Comments / Objections re Planning Application 2021/62/91239/W

410/412 Birkby Road , Birkby Huddersfield, HD2 2DN

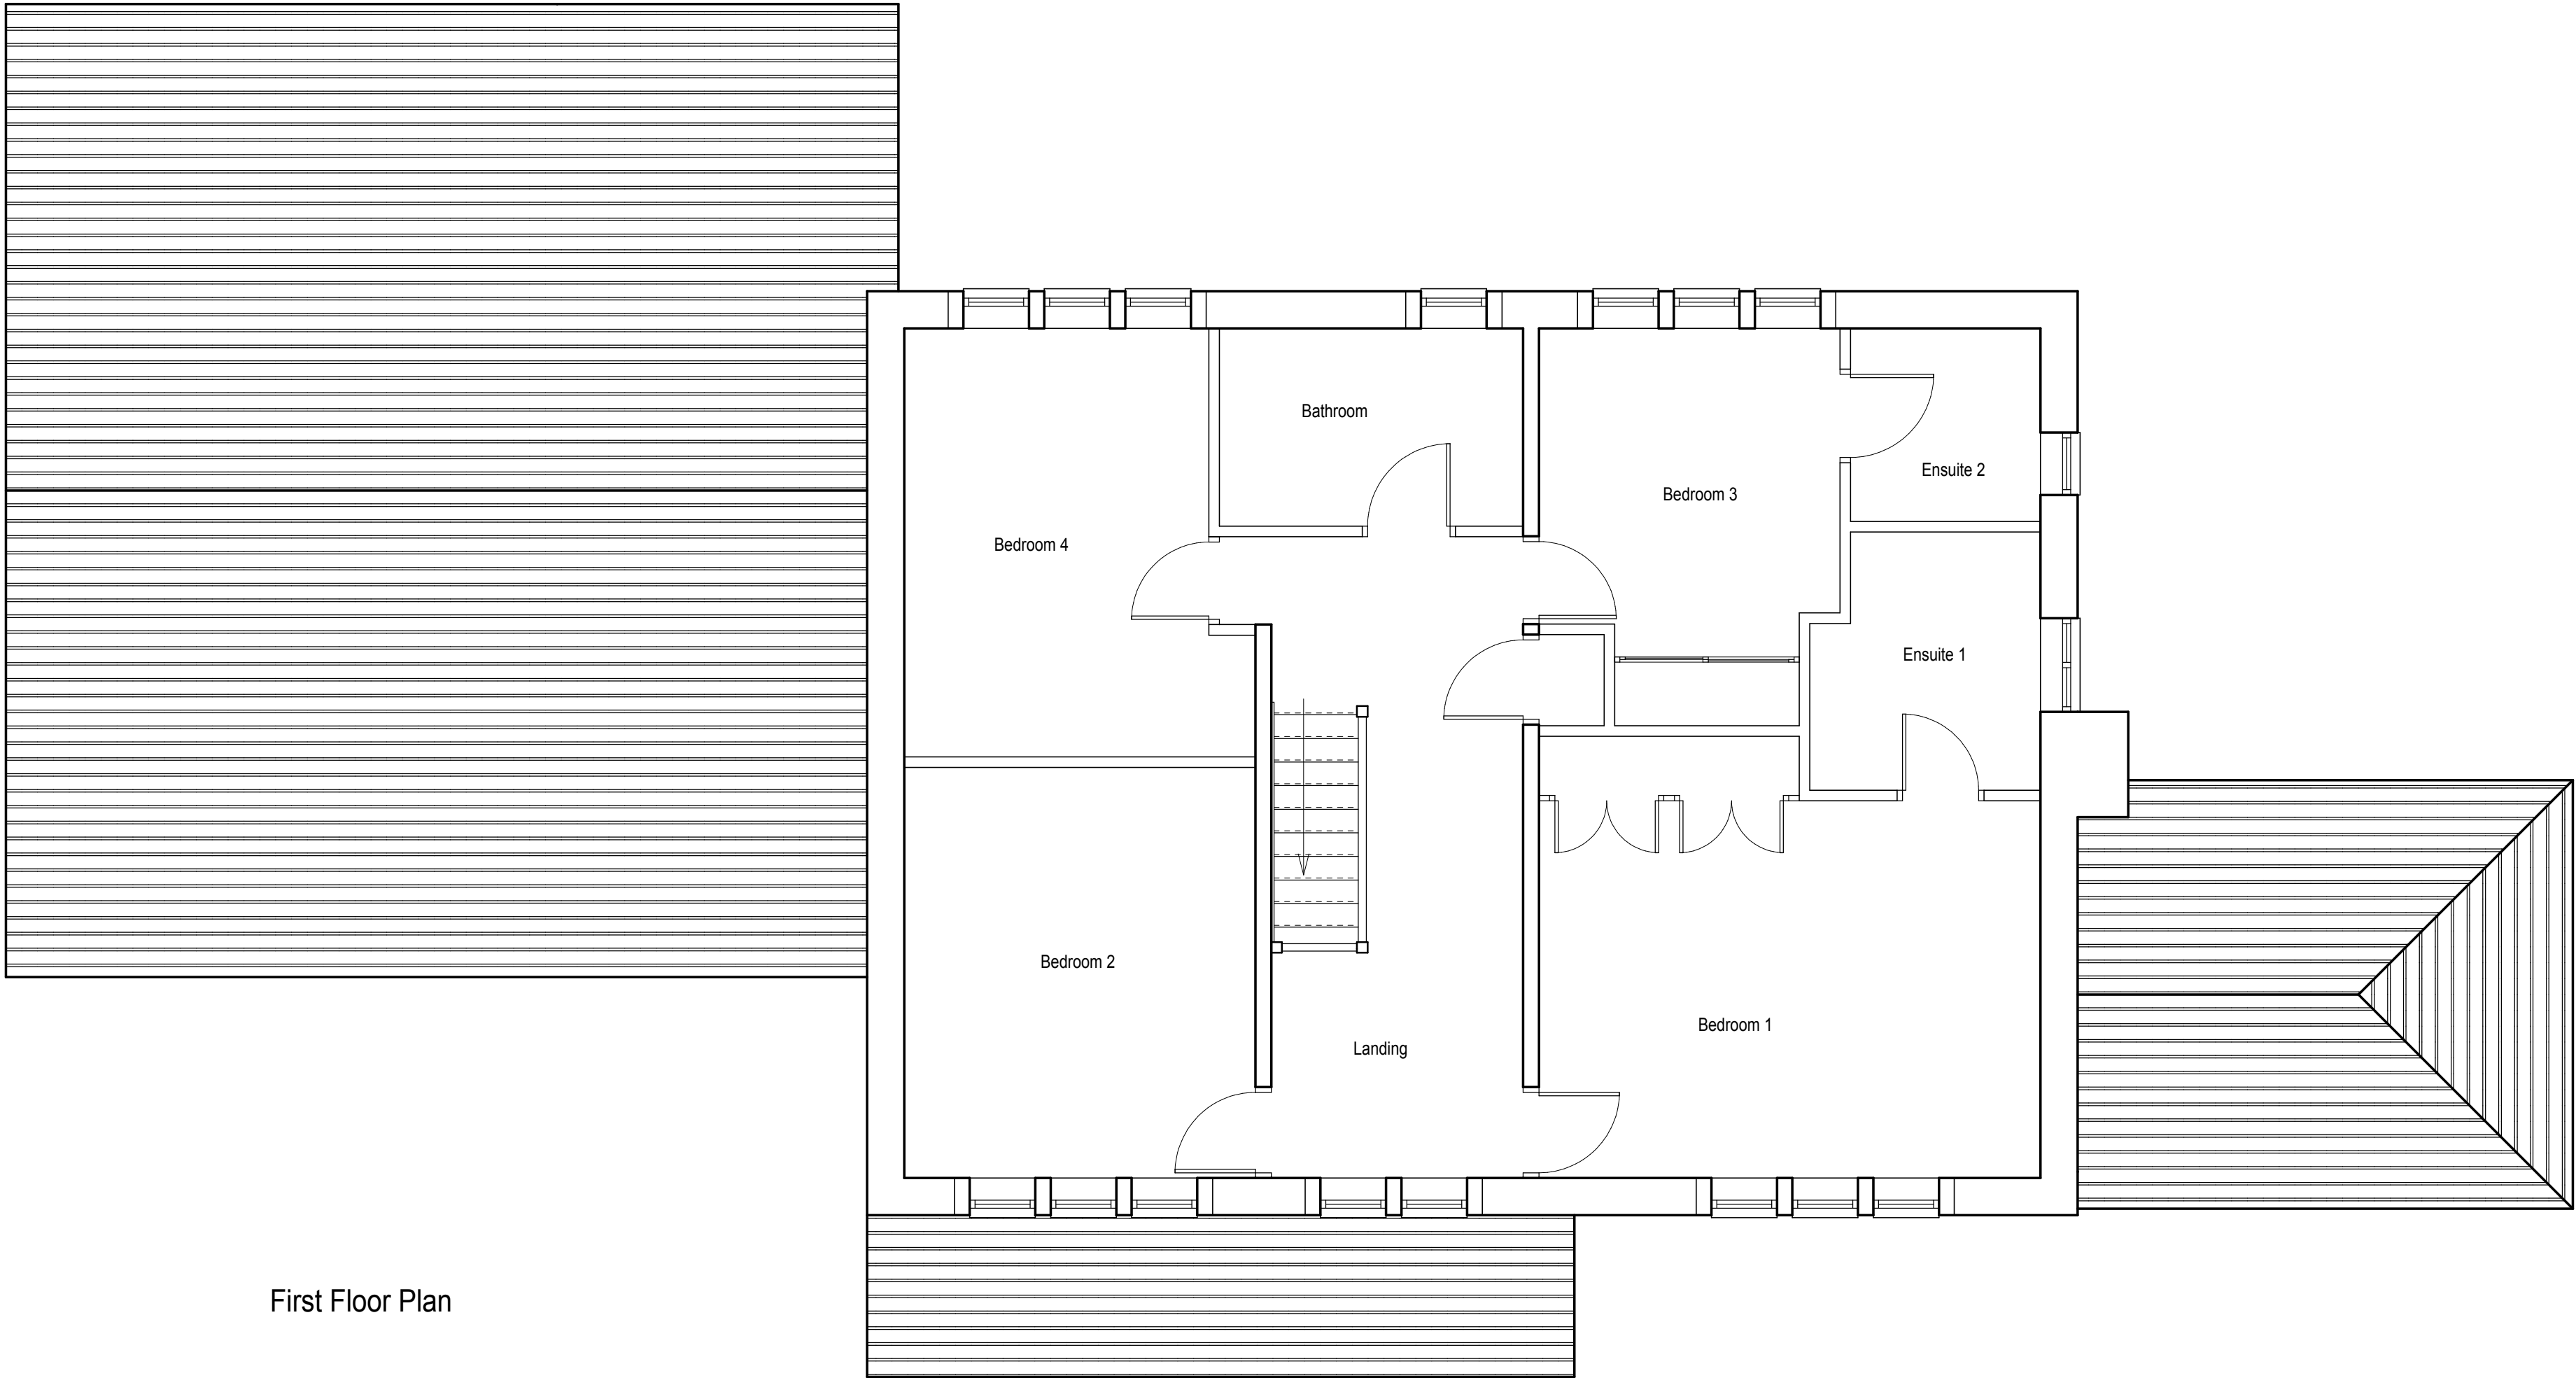
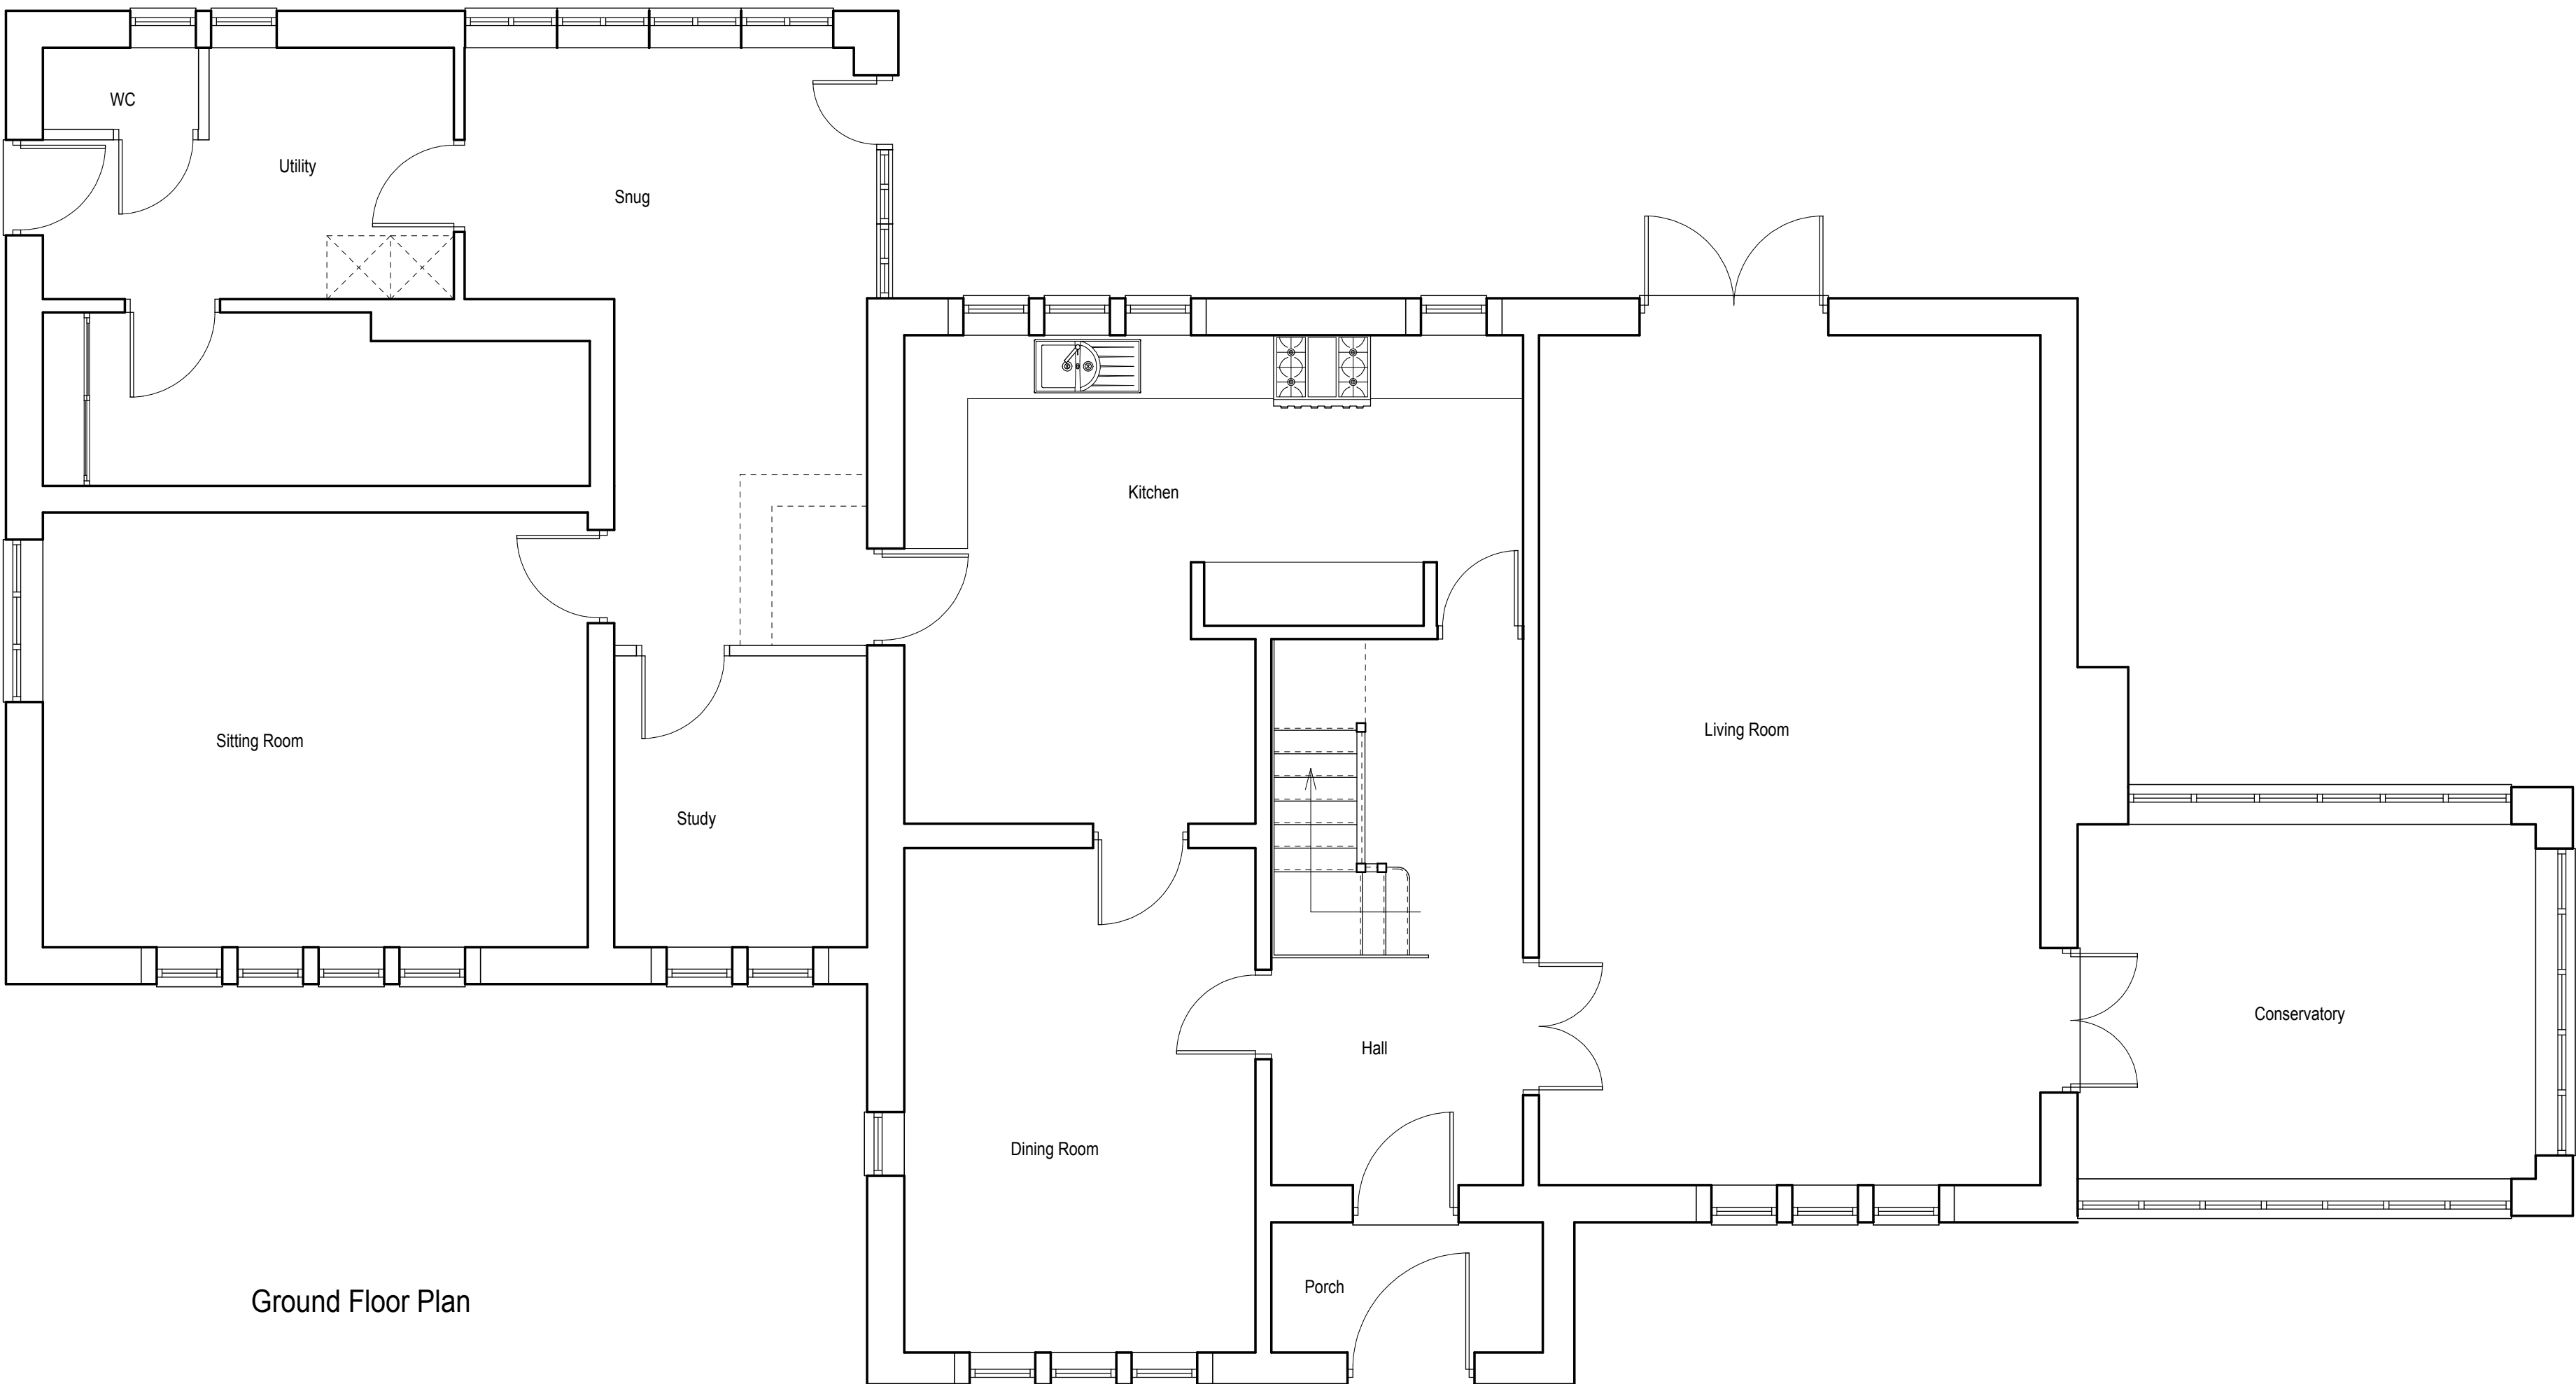
- It should be further noted that the proposed height of the new property is currently designed to be in excess of 9.0m. The ground level currently sits approx. 4.0m above the neighbouring properties, therefore meaning that the new property would at its highest point be circa 13.0m higher than the neighbouring properties.

- The entire back elevation is covered in balconies to the first floor which would mean a direct view down onto the neighbouring properties, specifically No 9 Valley Head, as well as views from the ground floor windows looking directly into the first floor rooms of the neighbouring properties especially No 7 Valley Head.

- The drawing is misleading!
- There are Measurements missing but to us and our professional advisors the overall height of the roof doesn't seem correct for the pitches to work! Perhaps the overall height is not true?
